Our Ref: WA/84/18/HH

**Town & Country Planning Act 1990 (as amended)
Town & country Planning (Development Management Procedure) (England) Order 2015
Application for Planning Permission for Works or Extension to a Dwelling**

Development Extensions and alterations to bungalow including first floor extension. New garage with home office

Location Willows West Walberton Lane Walberton

SITE PLAN
SCALE 1:500

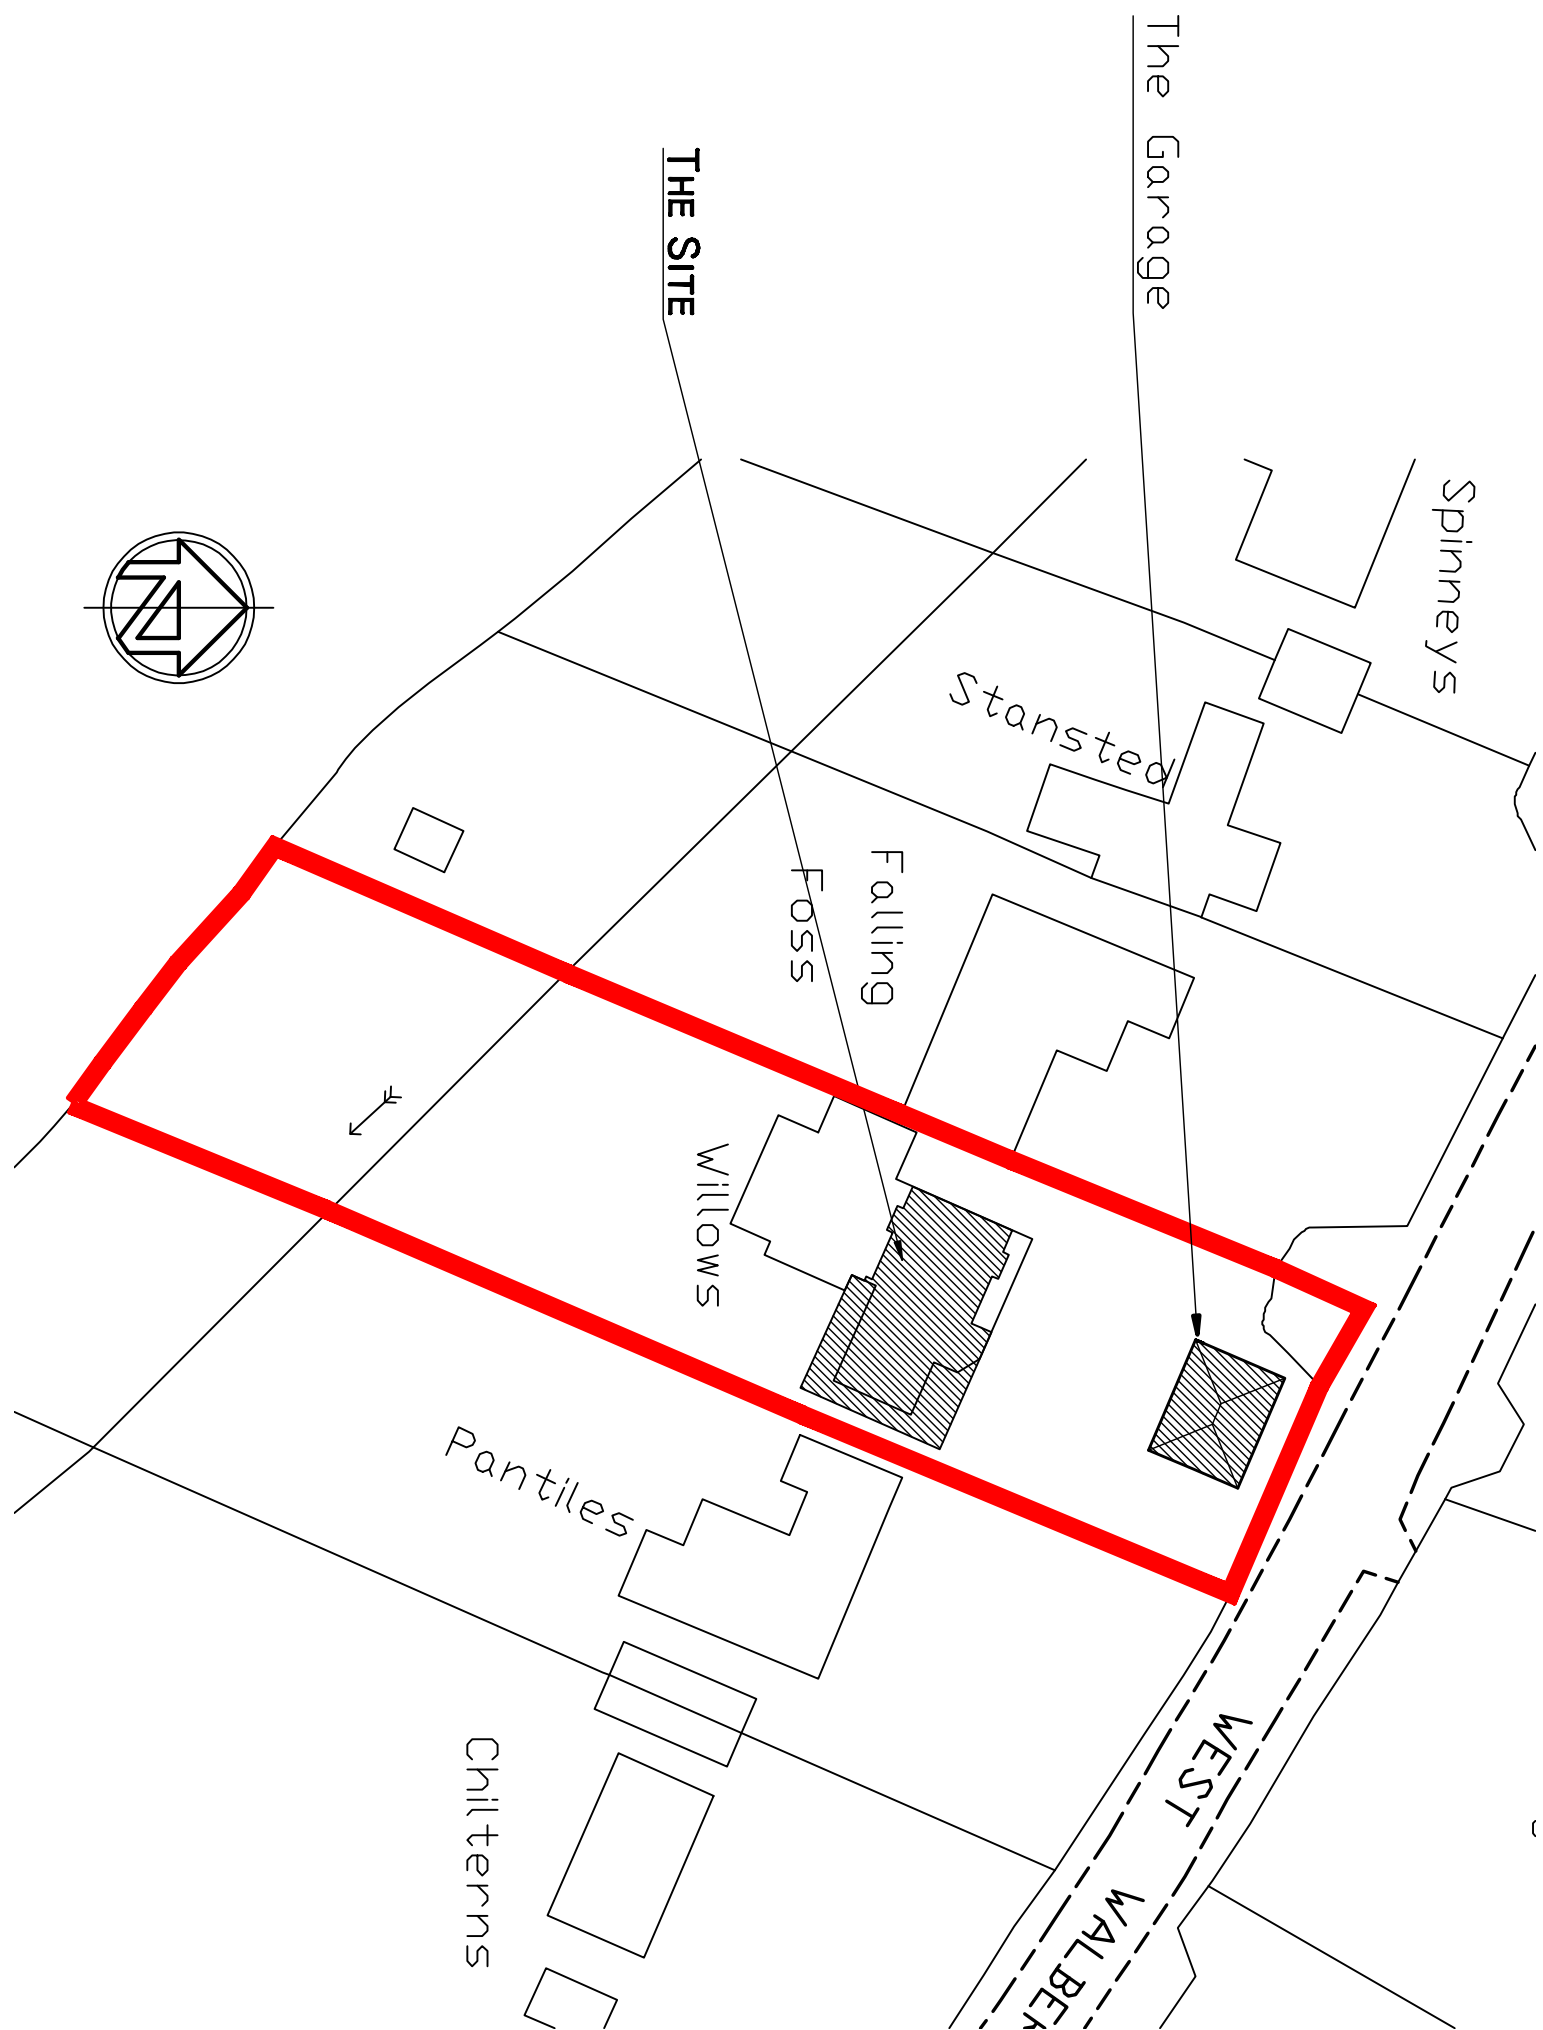
Block Plan

Please submit 1 electronic or 3 paper copies of an amended block/site plan at a scale of 1:500 or 1:200 showing the measurements to the boundaries from the proposal.
